Date: 9th July 2019
Our Ref: 14/351

Re: MP07_0026 – Epiq Estate Lennox Head (Mod 7)

Table 1: Government Agency Submissions & Project Response

EPIQ ESTATE - LENNOX HEAD, NSW, 2478 SUPER LOT 5 CIVIL WORKS PLAN		
Reference No. 2014/351	DRAWING No. 14351-S5-DA-CI-01	REVISION B

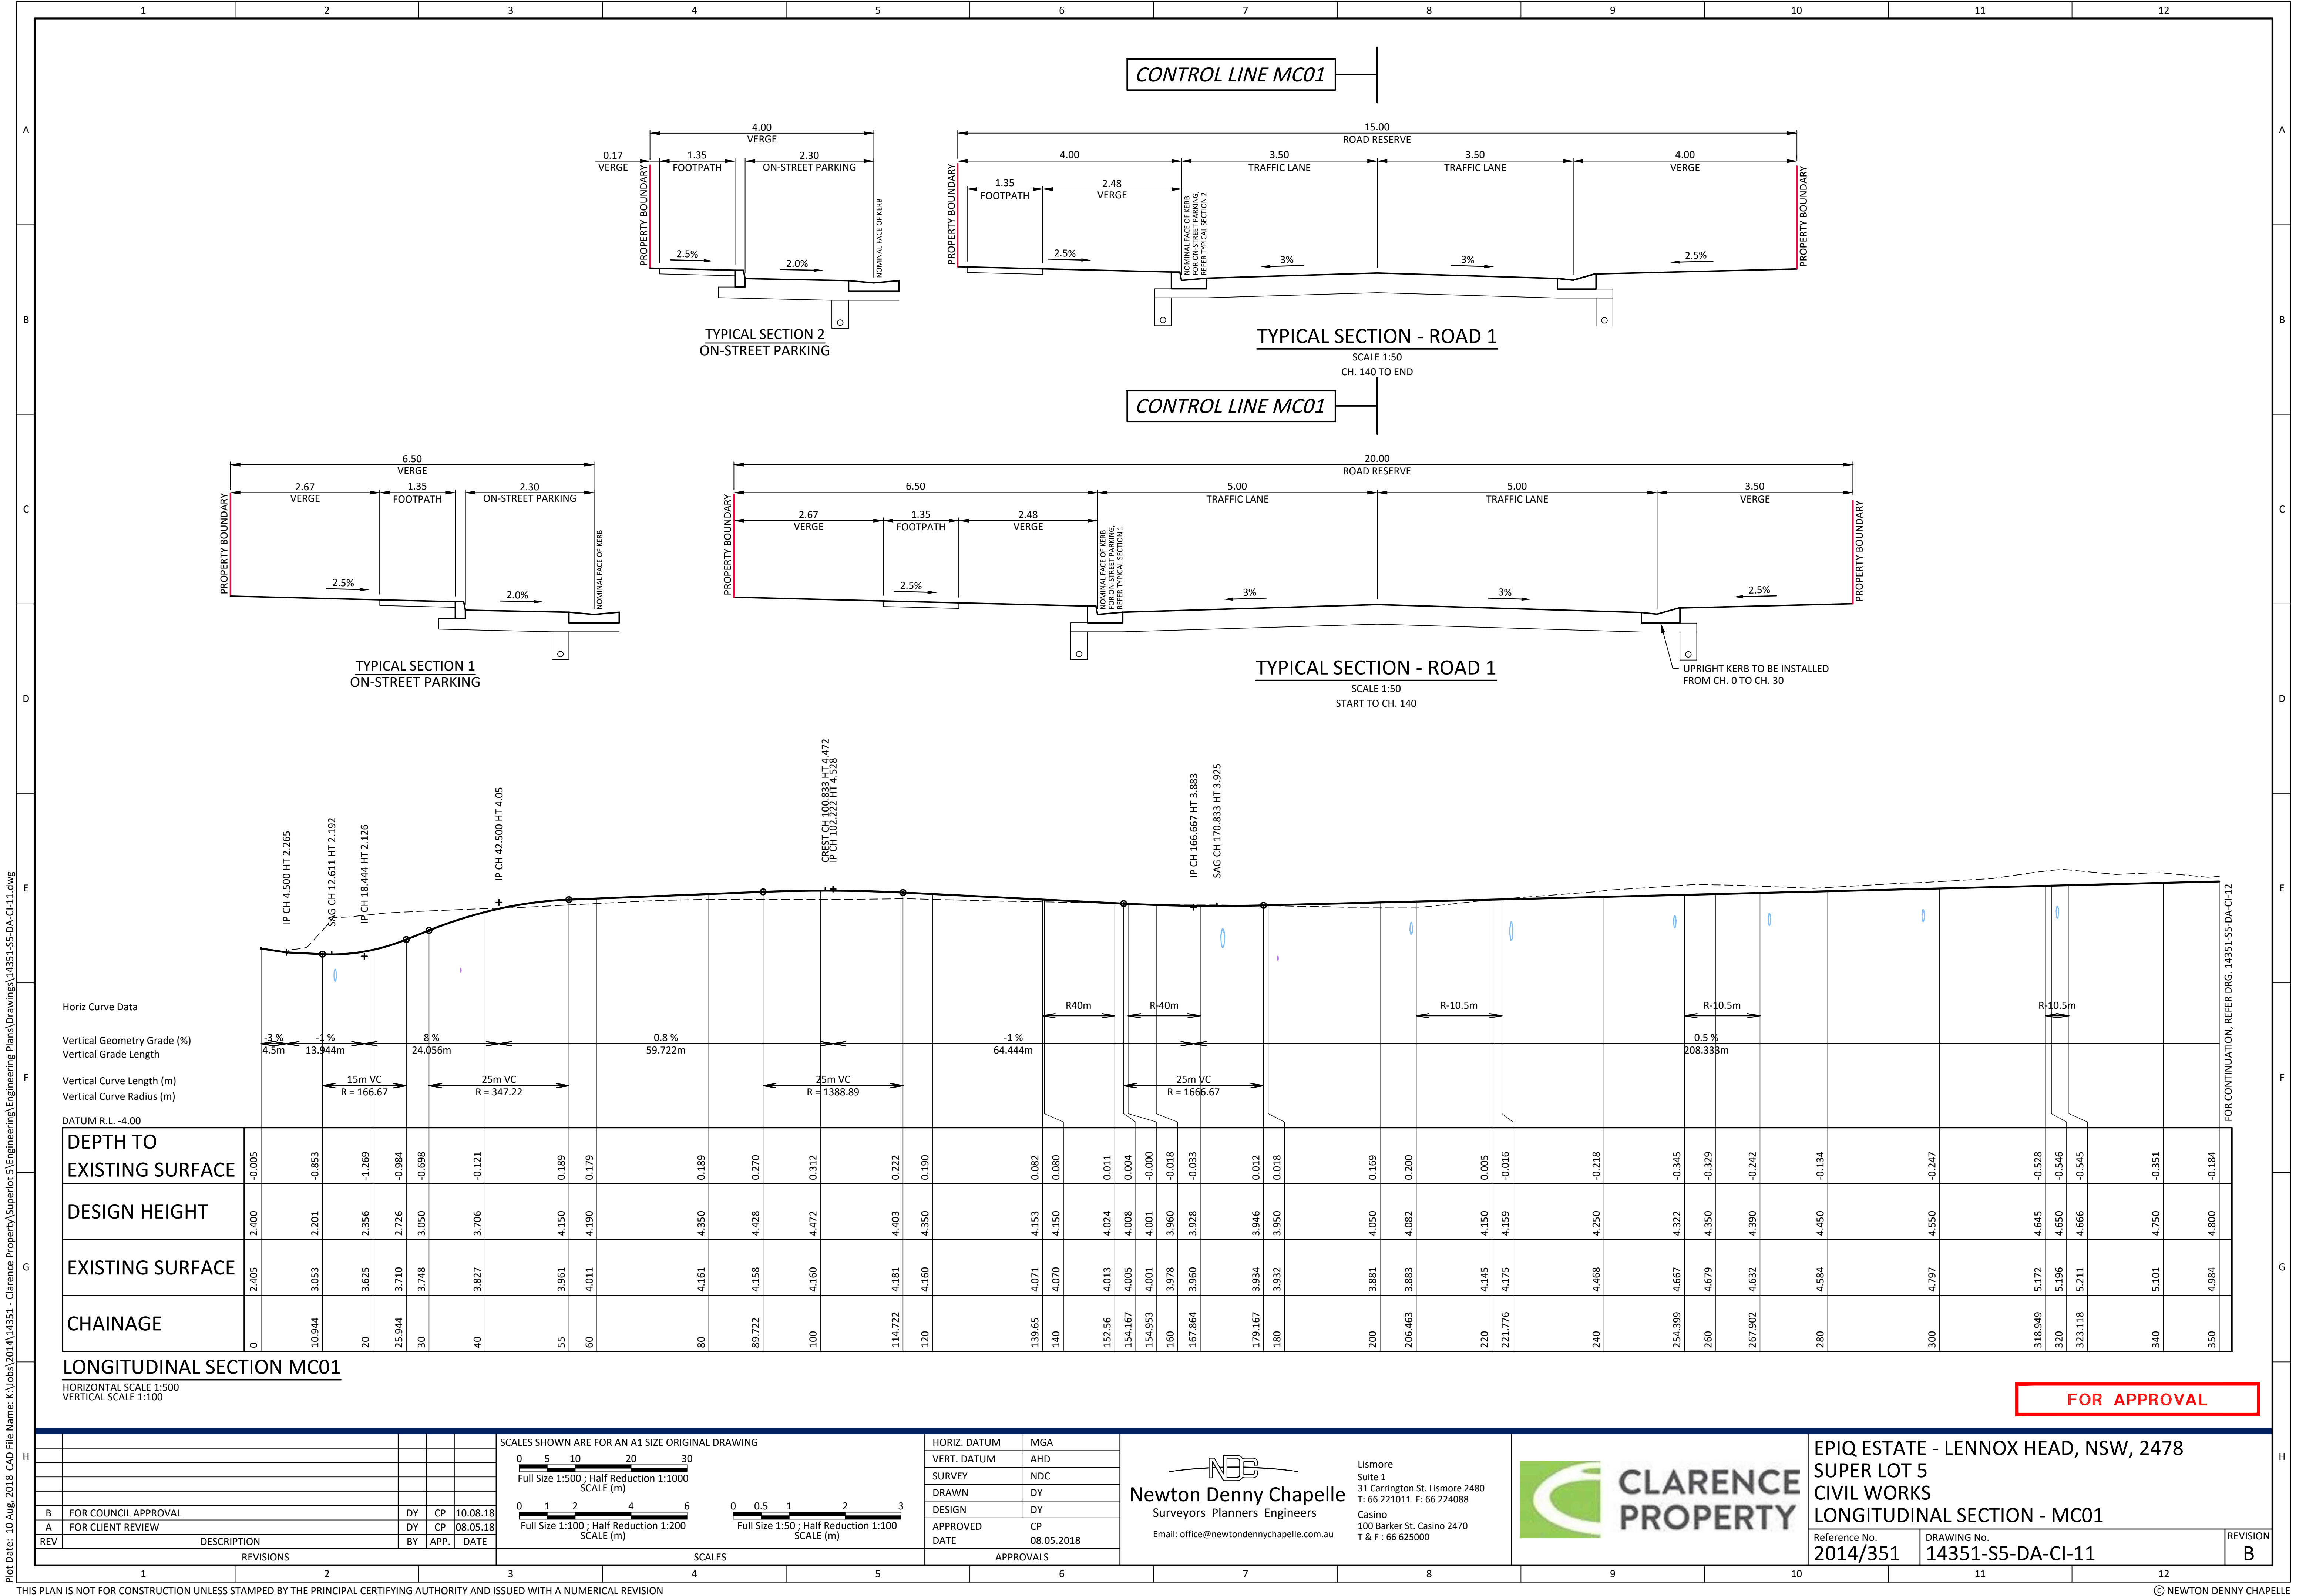
Government Agency	Agency Comments	Proponent Response
Ballina Shire Council	1. Perimeter Road (Council access and maintenance)	<p>It is acknowledged that the proposed layout does not include a 20 m buffer and therefore does not comply with the requirements of the approved Environmental Management Plan (EMP) and Condition B10 of the Concept Approval. Section 6.1.1 of the EMP states that a 20m buffer be applied to retained areas of freshwater wetland within the Conservation Zone, not a 20 m buffer to the entire Conservation Zone. Mapping of the freshwater wetland was last undertaken in 2018 and is provided in the ecological response to Ballina Shire Council's submission within Attachment 1 of this letter.</p> <p>The intent of any buffer is to minimise negative impacts upon sensitive receiving areas. In this case, protection of the Freshwater Wetland EEC within the Conservation Management Zone (CMZ) which also contains threatened Square-stemmed Spike-rush (SSSR) and Hairy Joint Grass (HJG) is required. Reference is made to the fact the 20m buffer as contained under the existing Concept Plan Approval provides for the construction of a local access road upon Super Lot 5 which was to service the previously approved aged care housing designation for SL5. In this respect, the buffer did not comprise of a 20m landscaped buffer.</p> <p>A proposed track within a 5m-8m reserve plus a no build zone has been incorporated into the current design. The 5m buffer will comprise a 3m wide gravel access track (with localised widenings) and 2 m wide vegetated strip (refer Attachment 2). The proposed track would have less nutrient runoff than a local access perimeter road. In this respect, the intent of the 20m buffer would be met through the ability to achieve the Epiq Estate stormwater management plan through the building setback & 5-8m reserve area which equates to a minimum 10m buffer. Further reference to commentary on the stormwater management for the project is provided under Point 4 of this letter.</p> <p>Regard is also made to crime prevention and the design of the proposed perimeter maintenance access. In this respect, the track will have lockable bollards erected at each end where the track connects to the public road network. Further, an option also exists to incorporate a fence and gate at the road frontage to provide further access restrictions is deemed appropriate by Council. This measure will clearly delineate access and use of the track is not for public access. Furthermore, the utilisation of a gravel finish discourages the use of the access track for skateboards or scooters which may occur with a concrete surface, thereby reducing the attraction for children to utilise the track.</p>

4. Potential impacts of filling on the Hydrology of the Conservation Zone	<p>The Revised Stormwater Assessment & Management Plan, Pacific Pines Estate, prepared by Gilbert and Sutherland, (July 2014) was approved by BSC on 6 August 2014.</p> <p>This Plan outlines the philosophy for stormwater management across the greater Epiq Estate. The majority of stormwater generated by the development is to be discharged to the Water Quality Control Pond (WQCP) which is located to the west of Montwood Drive. Water generated by the development to the east of Montwood Drive is to be discharged to the Conservation Management Zone (CMZ) from which it passes through the existing box culverts installed under Montwood Drive.</p> <p>All previous stages of the Epiq Estate have been designed and constructed generally in accordance with this Plan. It is noted that several gross pollutant traps (GPT's) in addition to those identified in the Plan, have been installed as part of previous stages. These devices will improve the quality of the water entering the Conservation Zone and also remove devices previously proposed within the zone.</p> <p>The proposed Super Lot 5 development has been redesigned to provide an access track around the perimeter of the site. This track will be constructed 3m wide in accordance with BSC standards. Energy dissipators have been provided outside the CMZ as required by Council and are detailed on the attached engineering plan 14351-S5-SK-DR-01-B. An additional drain has been proposed adjacent to the west side of Montwood Drive to address Council's concerns regarding the drainage of low lying areas of the CMZ. The location and configuration of this drain has been developed in consultation with Ballina Shire Council.</p>

6. Stormwater Conveyance – Points of Discharge	Reference is made to the response provided for Point 4
	7. Stormwater Conveyance – Overland Flow Path	As suggested by Ballina Shire Council the issues raised regarding overland flow paths have been overcome by providing perimeter access around Super Lot 5 and dedicating the nominated drainage easements.

The information provided generally addresses Council's previous concerns in relation to this proposed modification. Accordingly, Council raises no objection to this modification as depicted in Plan of Drainage Works (Drawing No. 14351-S5-SK-DR-01 Rev B – dated 28.03.19) prepared by Newton Denny Chapelle, subject to suitable conditions being imposed by the Department of Planning and Environment and the following design changes being made prior to the issue of any approval.

- *The proposed gravel access track around the southern and eastern perimeter of Super Lot 5 being increased to 3m in width with an additional 0.5m clearance on each side to facilitate access for maintenance vehicles.*
- *Provision of a central island in Montwood Drive to prevent right turn movements and restrict access to left in / left out only.*

Reference is made to the fact Drawing No. 14351-S5-SK-DR-01 Rev B has been updated to Rev C to incorporate the above recommendations of Ballina Shire Council and is provided within the design package contained within **Attachment 2** of this submission. The project design guidelines which also form part of the Modification have been updated to address the interface with the CMZ and associated APZ provisions (refer **Attachment 5**).

The proposed SL5 development has been redesigned to provide an access track around the perimeter of the site. This track will be constructed 3 m wide in accordance with BSC standards and serve the dual purpose of a drain. The water from the proposed stormwater outlets will be collected to the natural flow path identified by in Plate 2 of Council's correspondence. The proposed combined path/drain will convey the flows and be located close to bed level in this location. Energy dissipaters/ rock protection will be used to slow the flows prior to their entry into the Conservation Zone.
